**REQUEST**

Current Zoning: MUDD-O SPA (mixed-use development district, optional, site plan amendment)  
Proposed Zoning: MUDD-O SPA (mixed-use development district, optional, site plan amendment)

Approximately 36 acres located on the west side of Providence Road, north of Fairview Road, and west of Columbine Circle.

The petition proposes to combine four apartment buildings into two buildings without an increase the number of dwelling units. The site is currently developed with two new structure-parked apartment buildings and 17 garden-style apartment buildings dating from the 1960s.

**RZ-100**

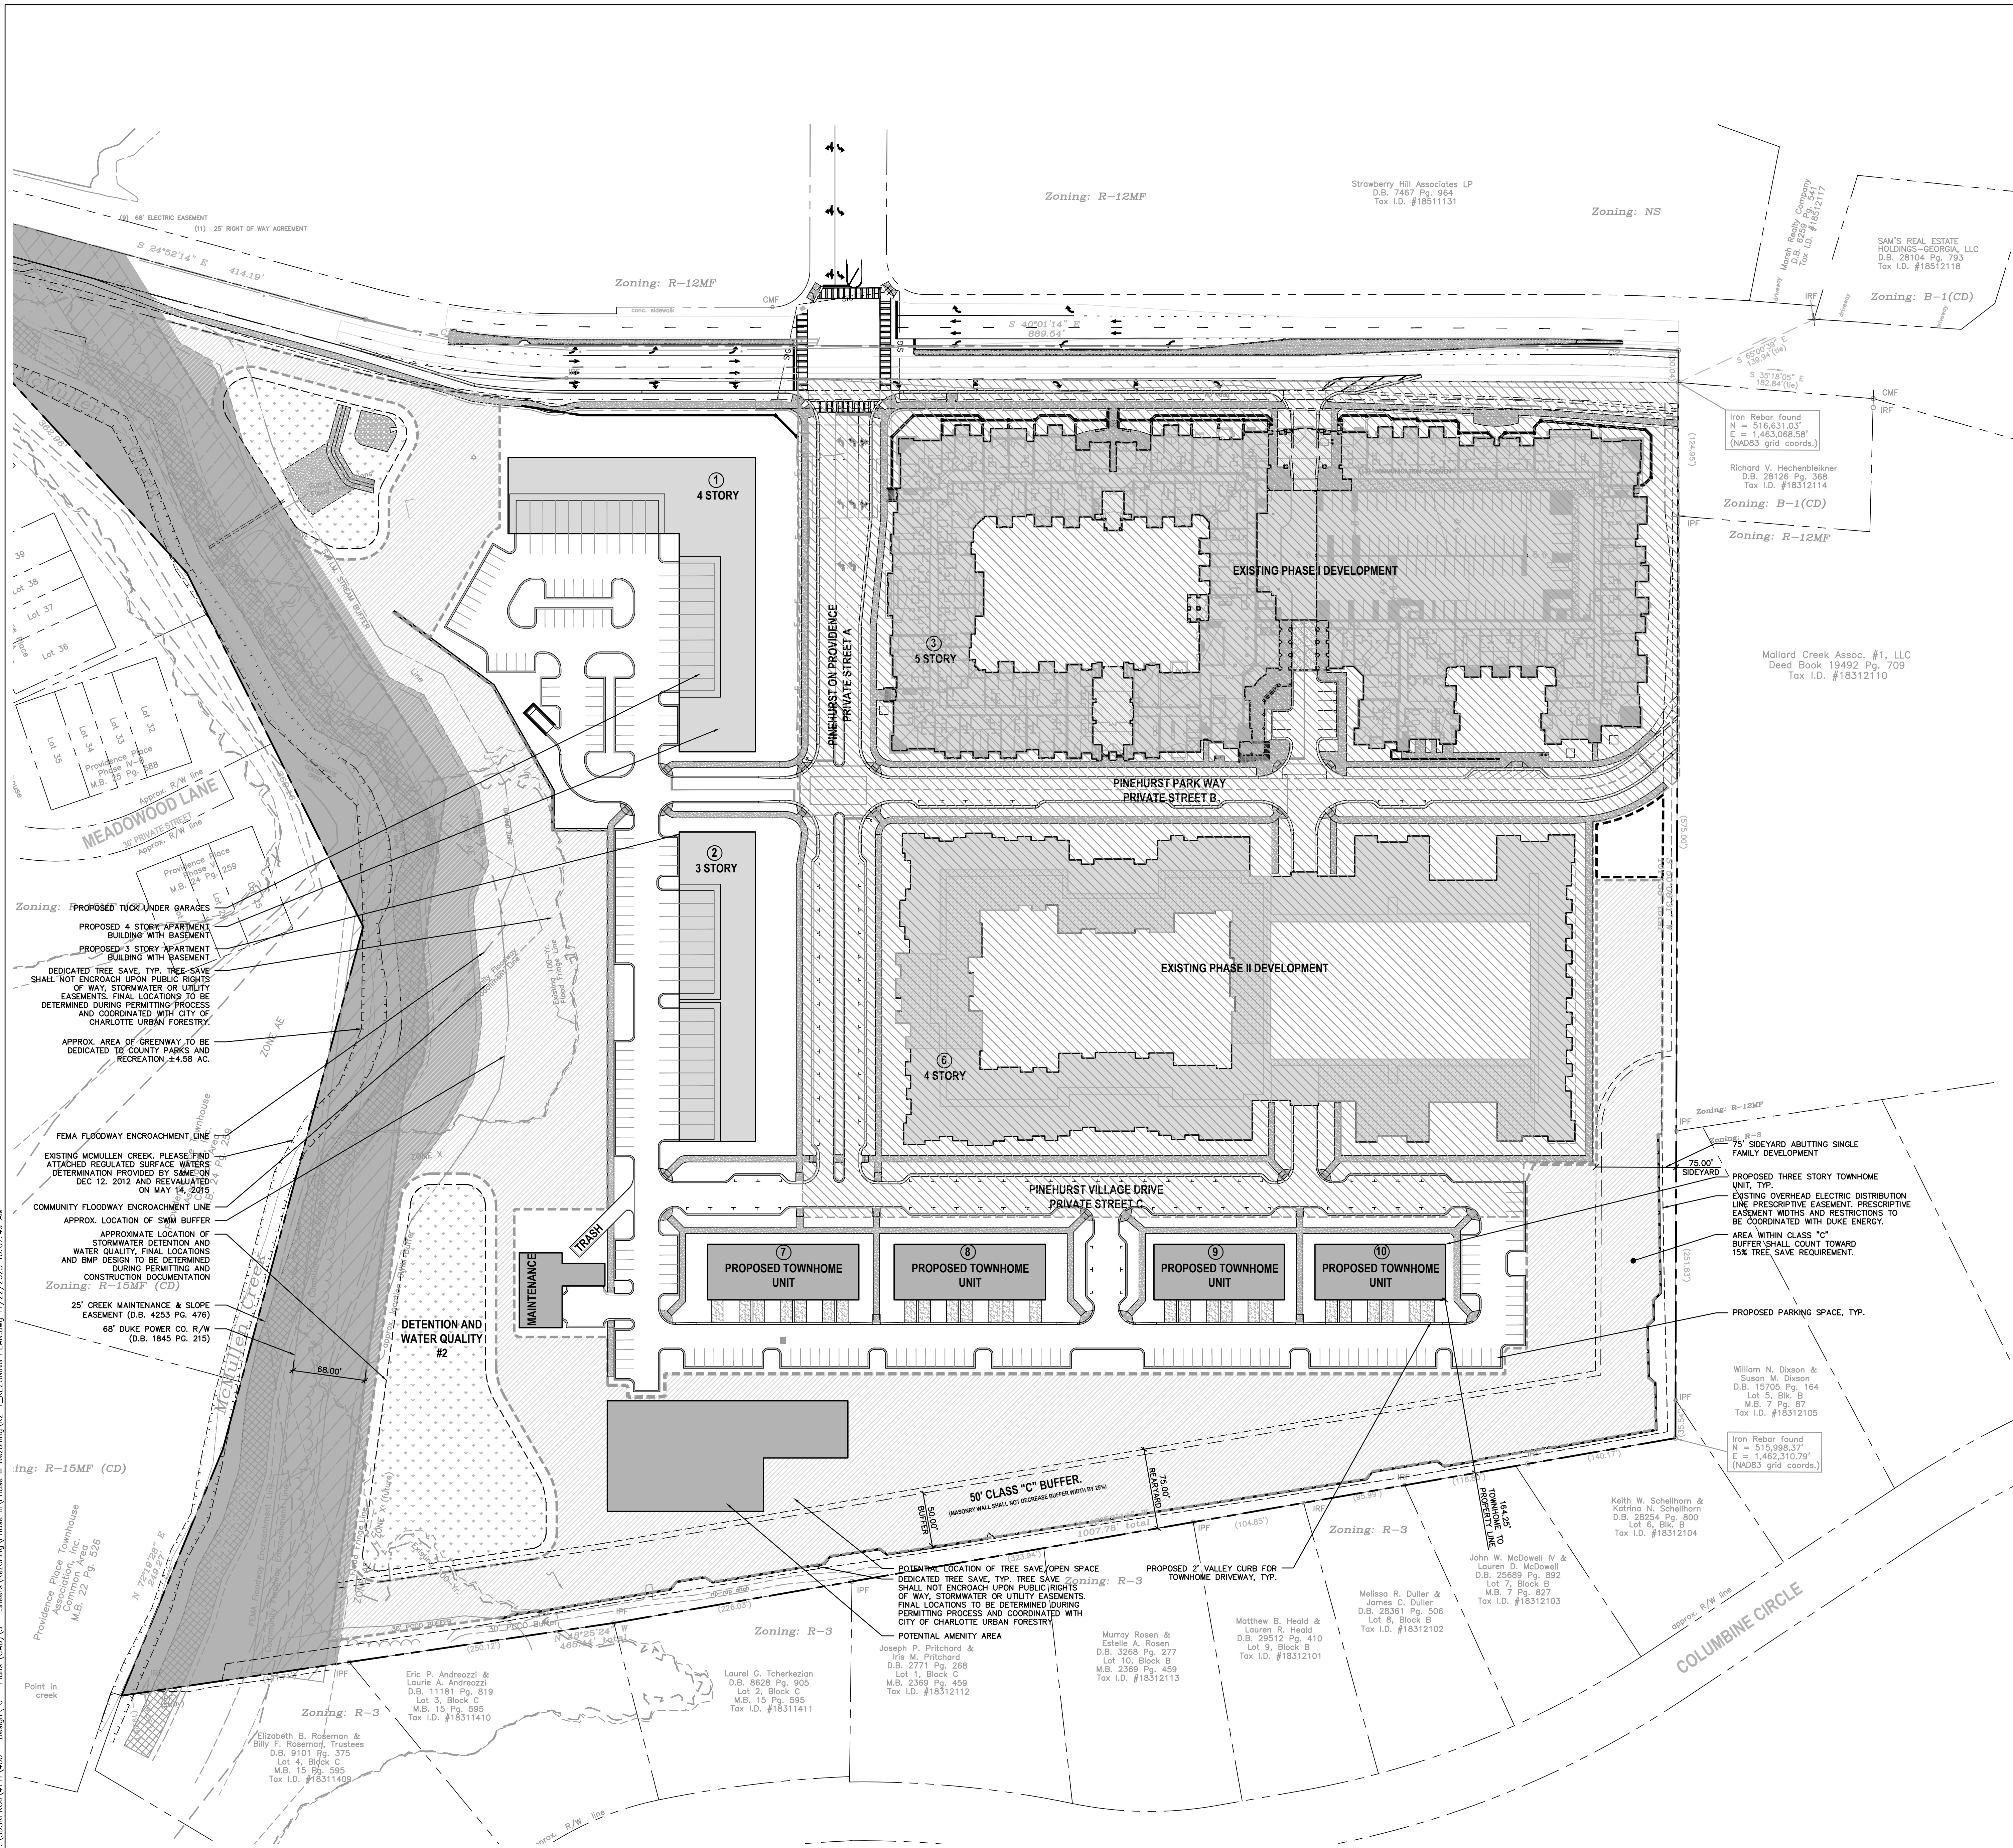
1. Mecklenburg County Park and Rec: The proposed greenway access easement must connect to the public street ROW to provide Mecklenburg County access to the greenway dedication area. This easement shall overlap with the private street between the public street ROW and the greenway area.

2. Stormwater Services Land Development: The rezoning plan proposes encroachments into SWIM and/or Post Construction Stormwater Ordinance stream buffers. Any increase of impervious area within such buffers may not be allowed and is not approved with the rezoning process. Please include the following note under Environmental Features: "Development within the SWIM/PCSO Buffer shall be coordinated with and subject to approval by Charlotte-Mecklenburg Storm Water Services and mitigated if required by City ordinance." Please note Stream Delineation Reports are subject to review and approval by Charlotte Storm Water Services.

3. Stormwater Services Land Development: Update label to say "100' SWIM and Post Construction Buffer." Buffer should be shown as extending 100' from top of bank.

4. Stormwater Services Land Development: add to note 8.d. under Environmental Features: "and mitigated if required by City ordinance."
5. Urban Forestry: Recommend changing the tree save conditional language. Based on what options are being used, tree save may be greater than 15%.

6. Urban Forestry: Tree save must meet min size requirements. Some of what is shown would not quality between the maintenance building and the water quality #2.
  7. Urban Forestry: While allowed, the amenity area within tree save would need to be accounted for at 150%
-
